# **KIRKLEES METROPOLITAN COUNCIL INVESTMENT & REGENERATION SERVICE**

### **DELEGATED DECISION TO DETERMINE PLANNING APPLICATIONS**

| Reference No:         | <b>2026/62/91347/E</b>                                                                                                           |
| Site Address:         | Cloverley, 119, Wakefield Road, Earlsheaton,<br>Dewsbury, WF12 8AF                                                               |

DRAWING NO: 901 - 008 - REV G  
SCALE: 1 : 50 @ A1

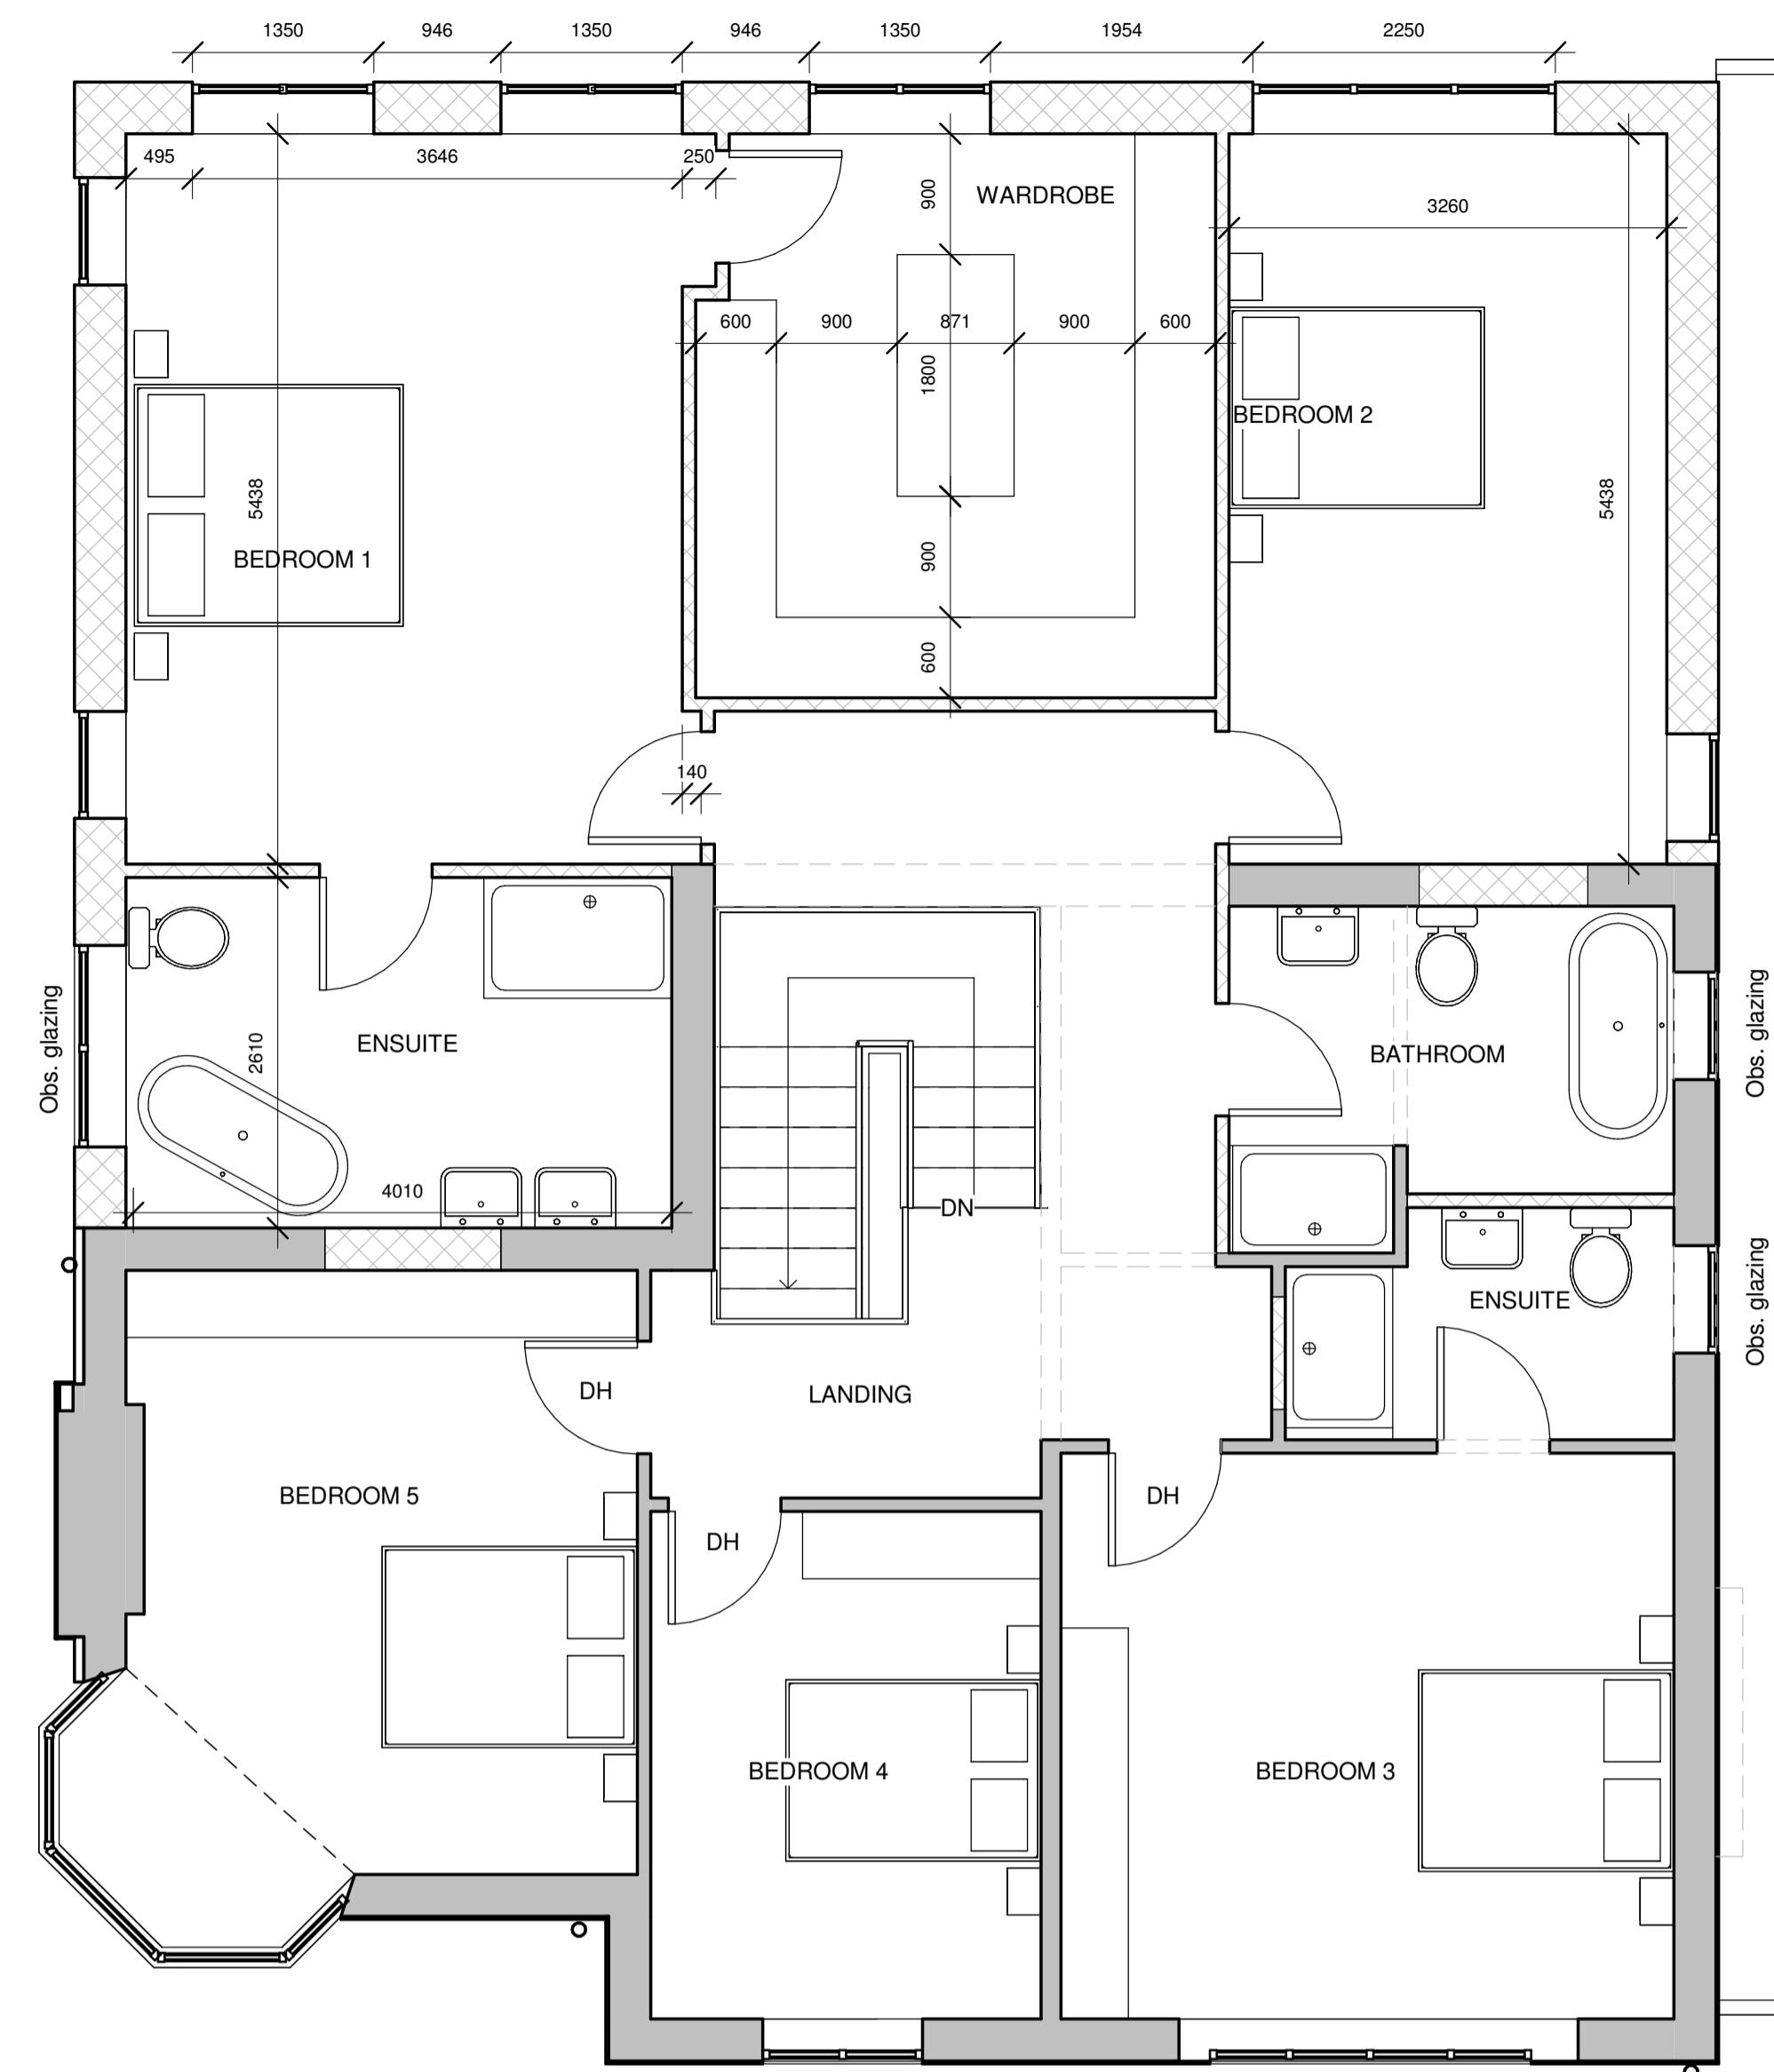
The side extension is proposed to project 7.5m from the original side wall of the dwelling, extending the depth of the property and to the side of the proposed rear extension. The roof form would be flat.

The two storey rear extension would project 5.8m from the original rear wall and would extend the width of the original dwelling with the new roof form over the main house being extended over the rear extension.

No.121 Wakefield road would be 14m from the side of the single storey flat roof extension to side, given this distance and the single storey design the proposal is not considered to significantly impact upon no.121 in terms of overshadowing, oppressiveness, overbearing or lead to a loss of privacy / overlooking. Furthermore, the distances involved are such that there would be no material overlooking or loss of privacy arising from the development.

901 - 007 - REV F

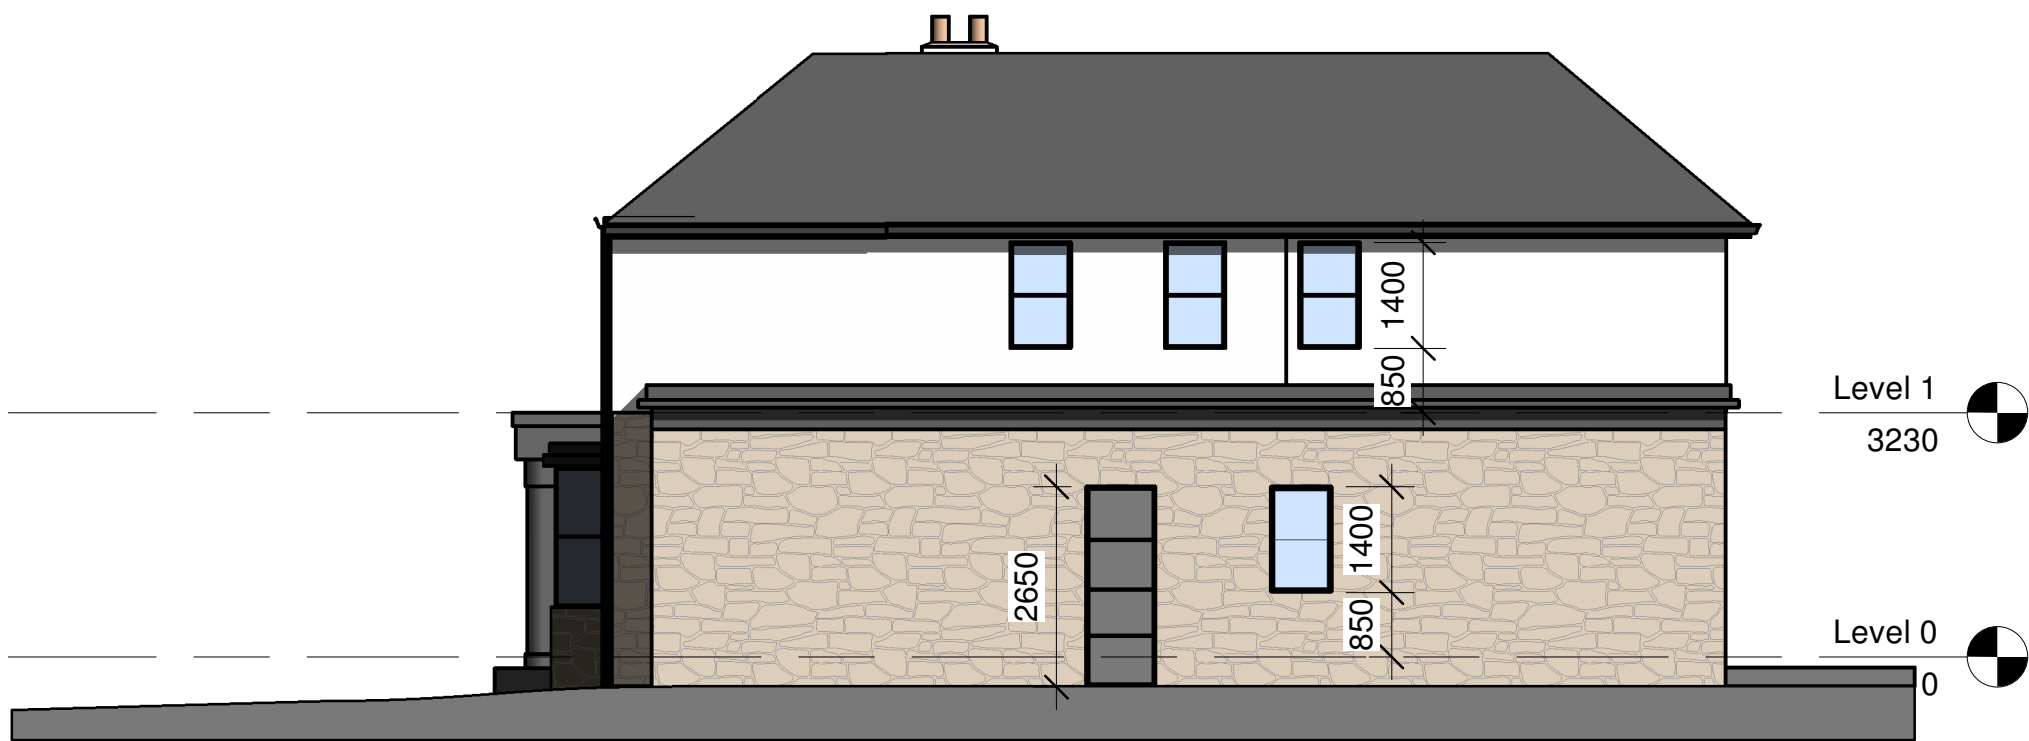
3. The external walls of the development hereby approved shall be natural stone at the ground floor in the locations so indicated upon submitted drawing 901-007-REVF and render of an off white or cream colour finish in the locations so indicated upon submitted drawing 901-007-REVF. The materials of construction shall be completed prior to the development being brought into use and retained thereafter.
